**Consultation Response from KC,
Lead Local Flood Authority**

2024/90792 Former Whiteley Engineering Works Site, St. Peg Lane, Cleckheaton, BD19 3SH

Use of land for assembly and storage and fit-out of acoustic containers of container-based generator units with reinstatement of access, erection of security fence and siting of cabins

Date Responded: 5th May 2024

Report No. 182623-F02	Drawing No. 02	Revision -
Scale As Shown	Date 26/01/2024	Frame Size A3
Produced By LC	Drawn By LC	Approved By RW

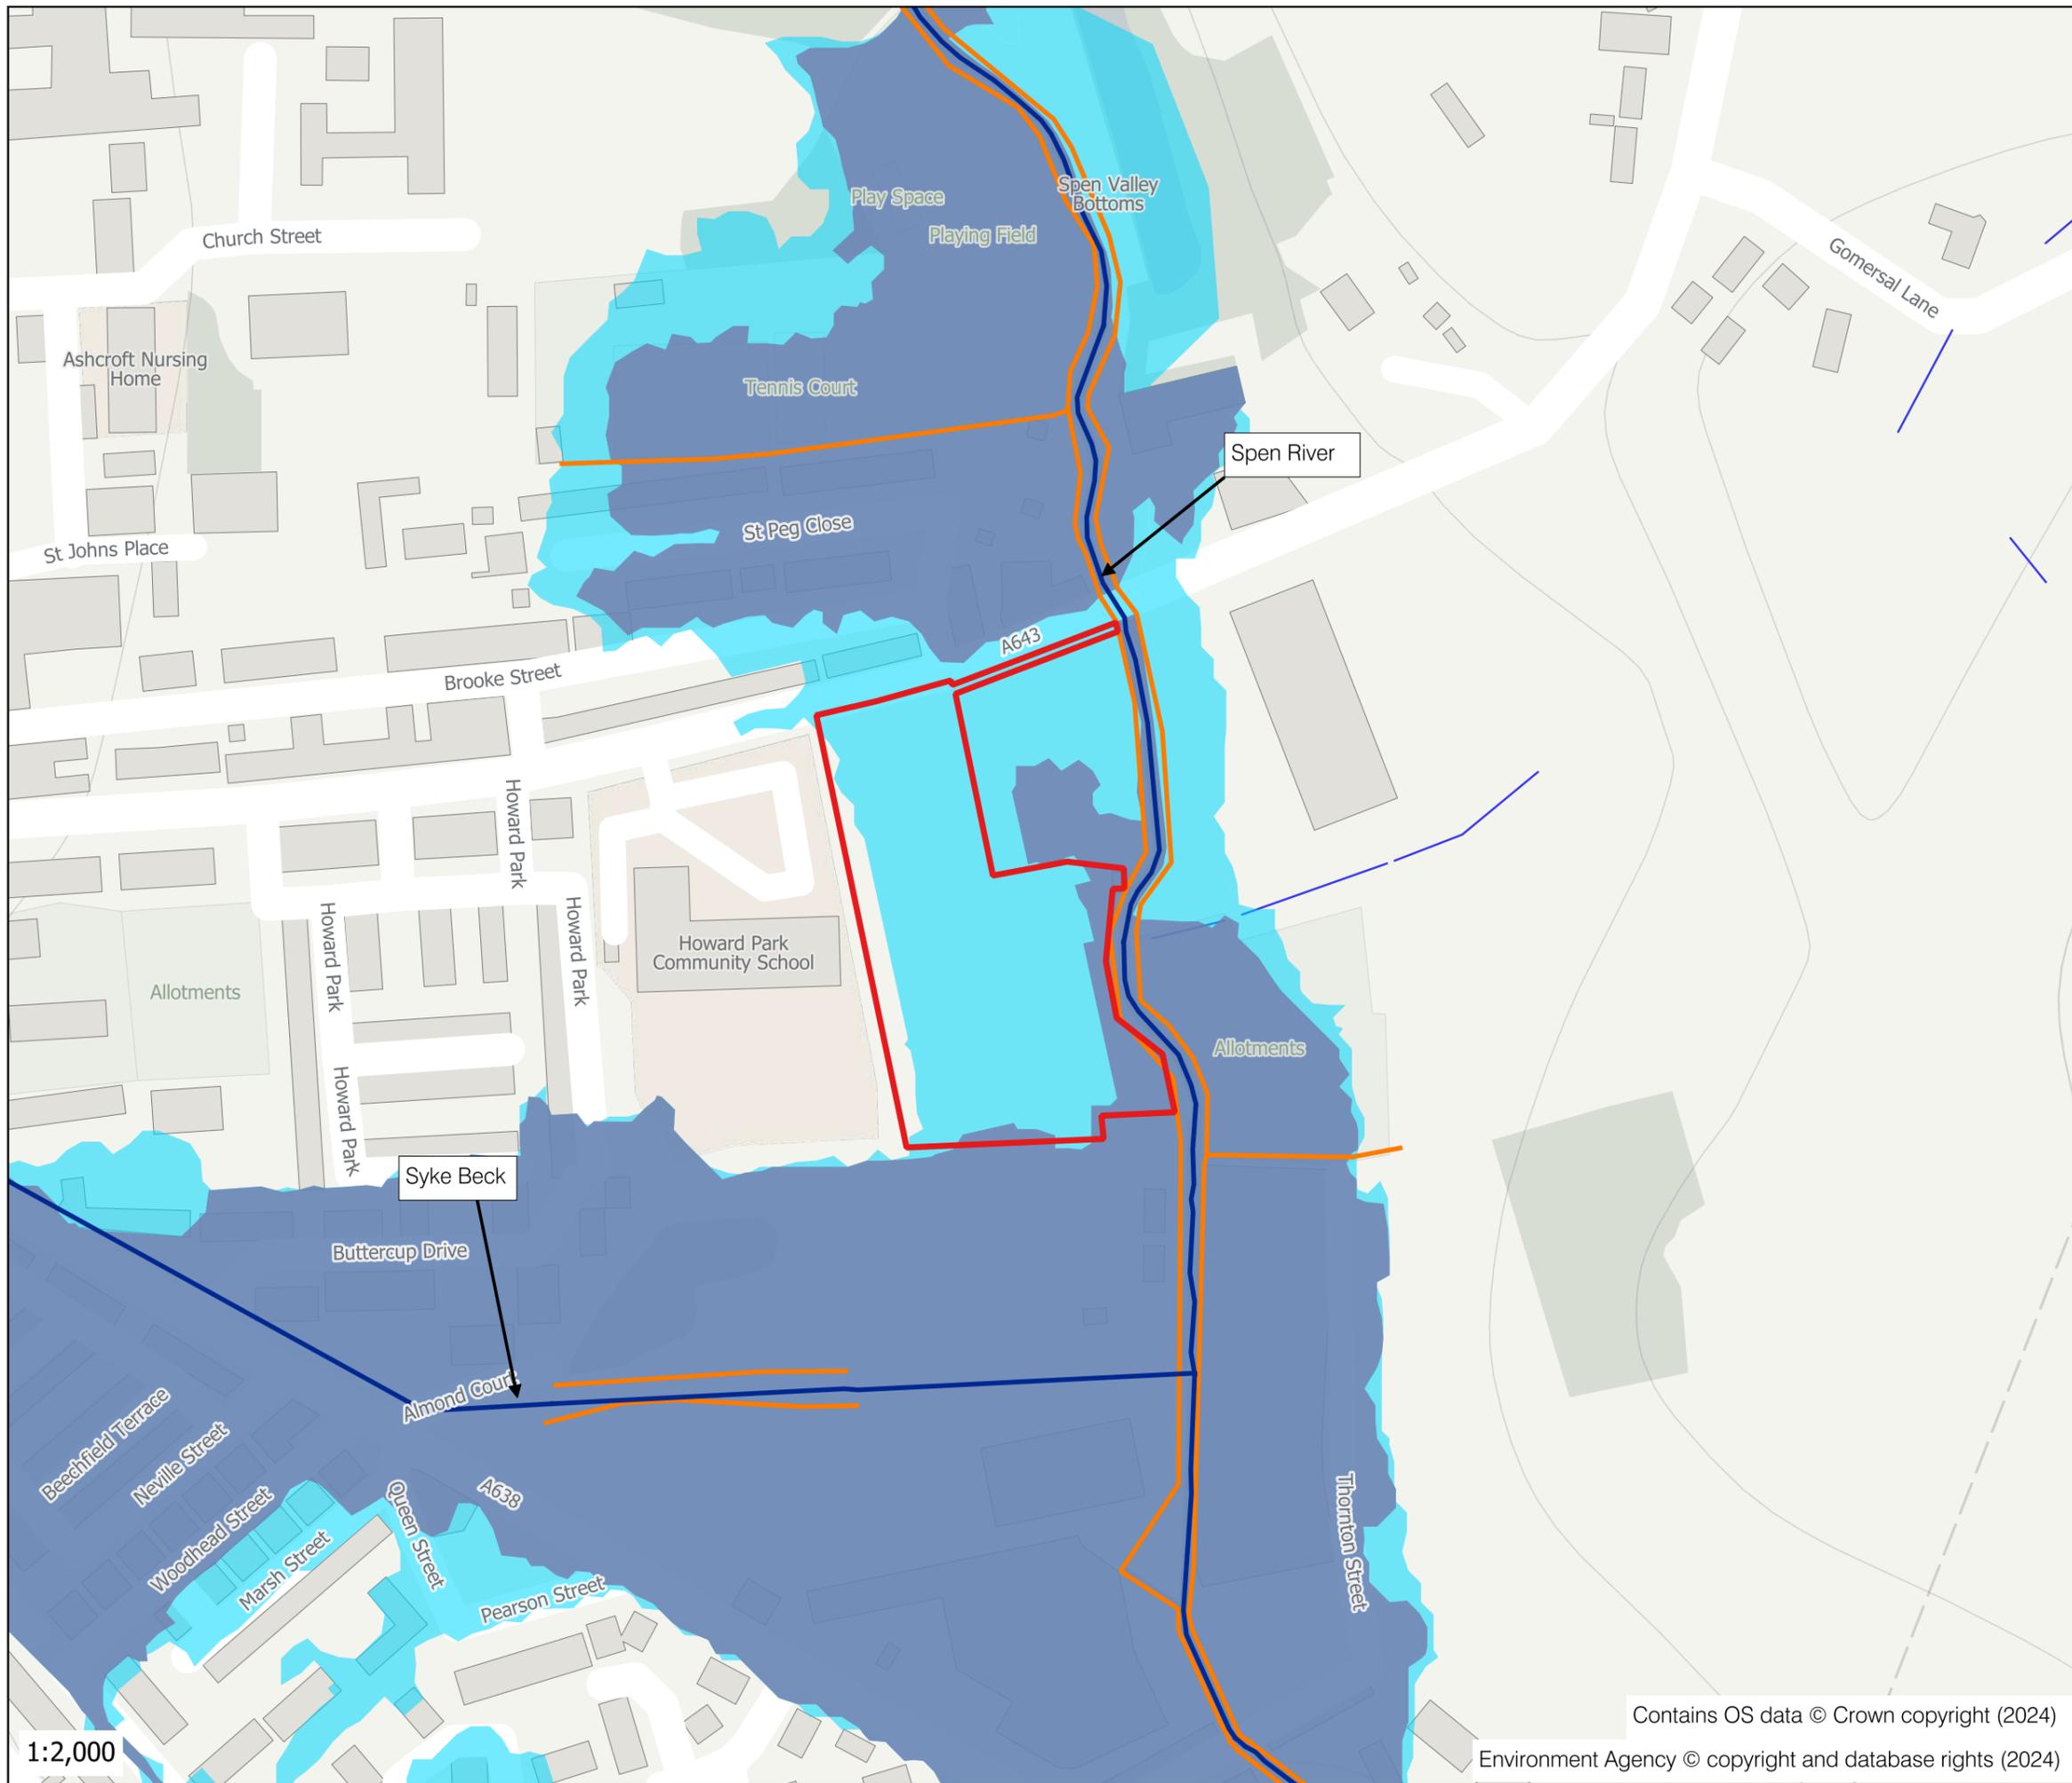
- The applicant needs to satisfy a sequential test with the majority of the site located in flood zone 2 with a portion of the eastern part of the site shown as flood zone 3 (adjacent to the river Spen).

Proposed Plans

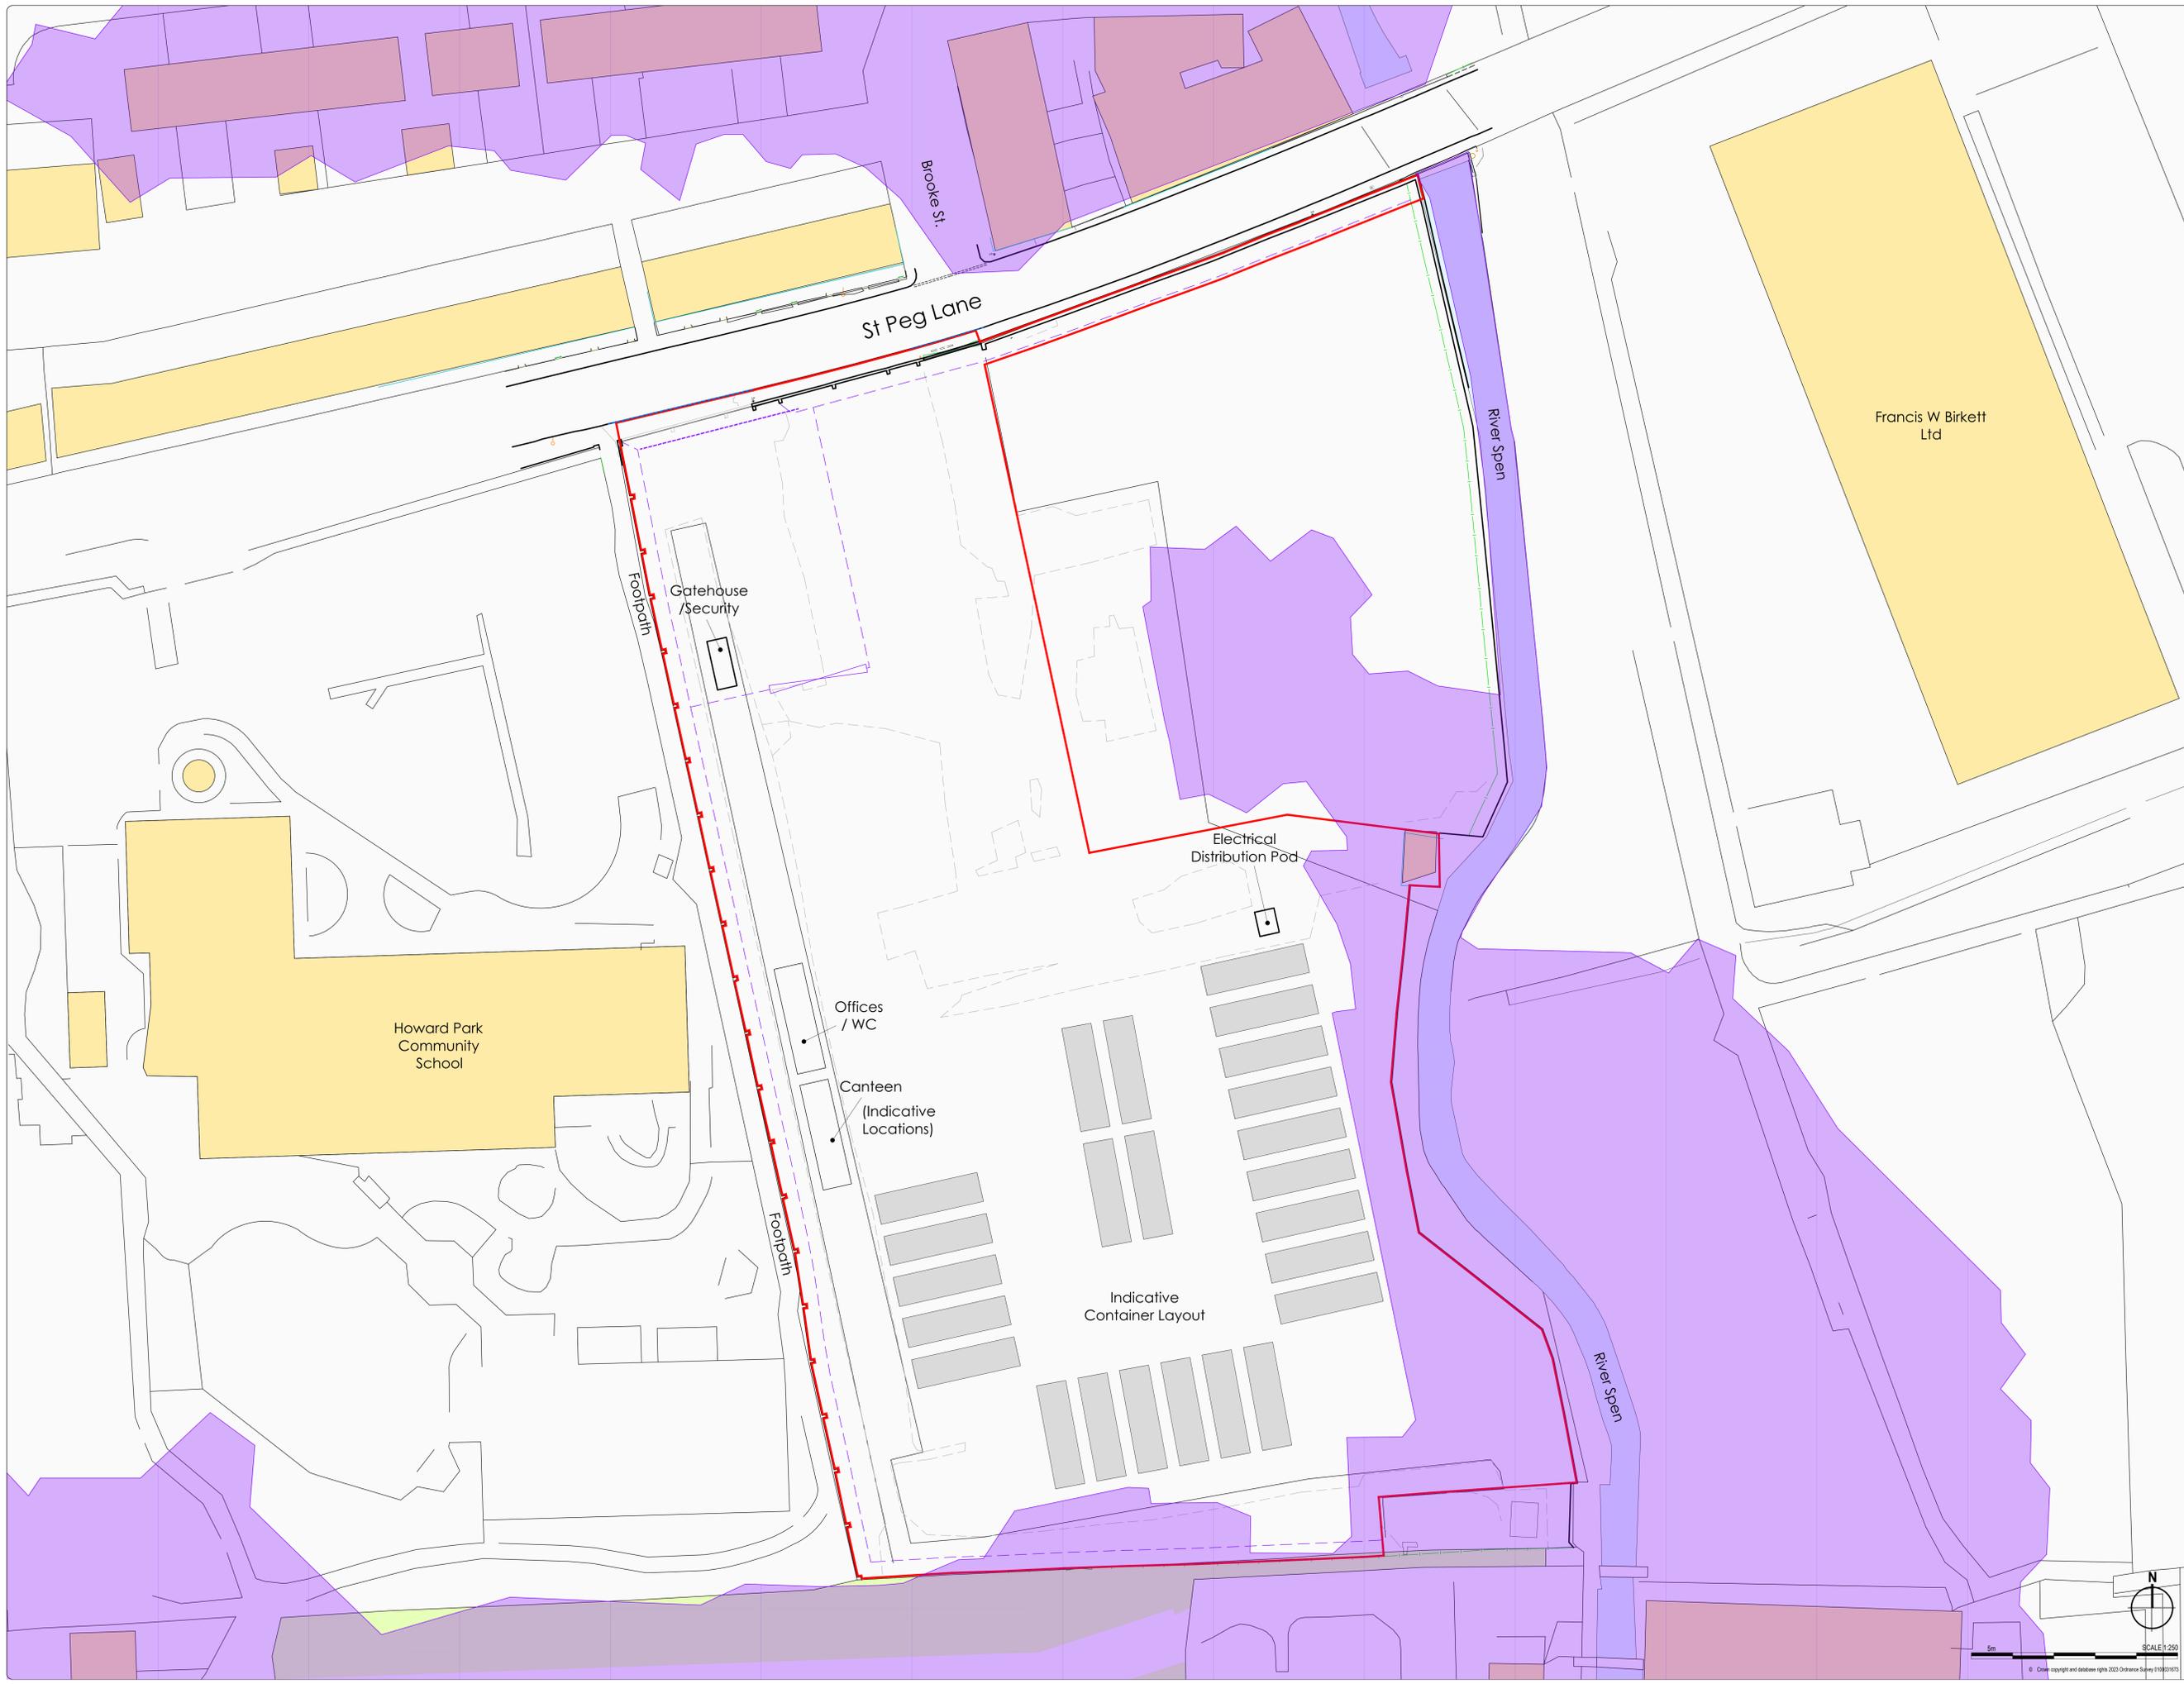
- Should a sequential test be passed, an exceptions test is not necessary. However, we would expect the applicant to adopt a sequential approach, i.e. position acoustic containers and electrical distribution pod to areas of least risk within the site.

- Containers stored in medium or high-risk flood zones would benefit from being fenced in. This is not clear at the riverside boundary. This is to counter residual risk of containers potentially floating in flood waters and becoming a hazard with regard to blockages under bridges etc.
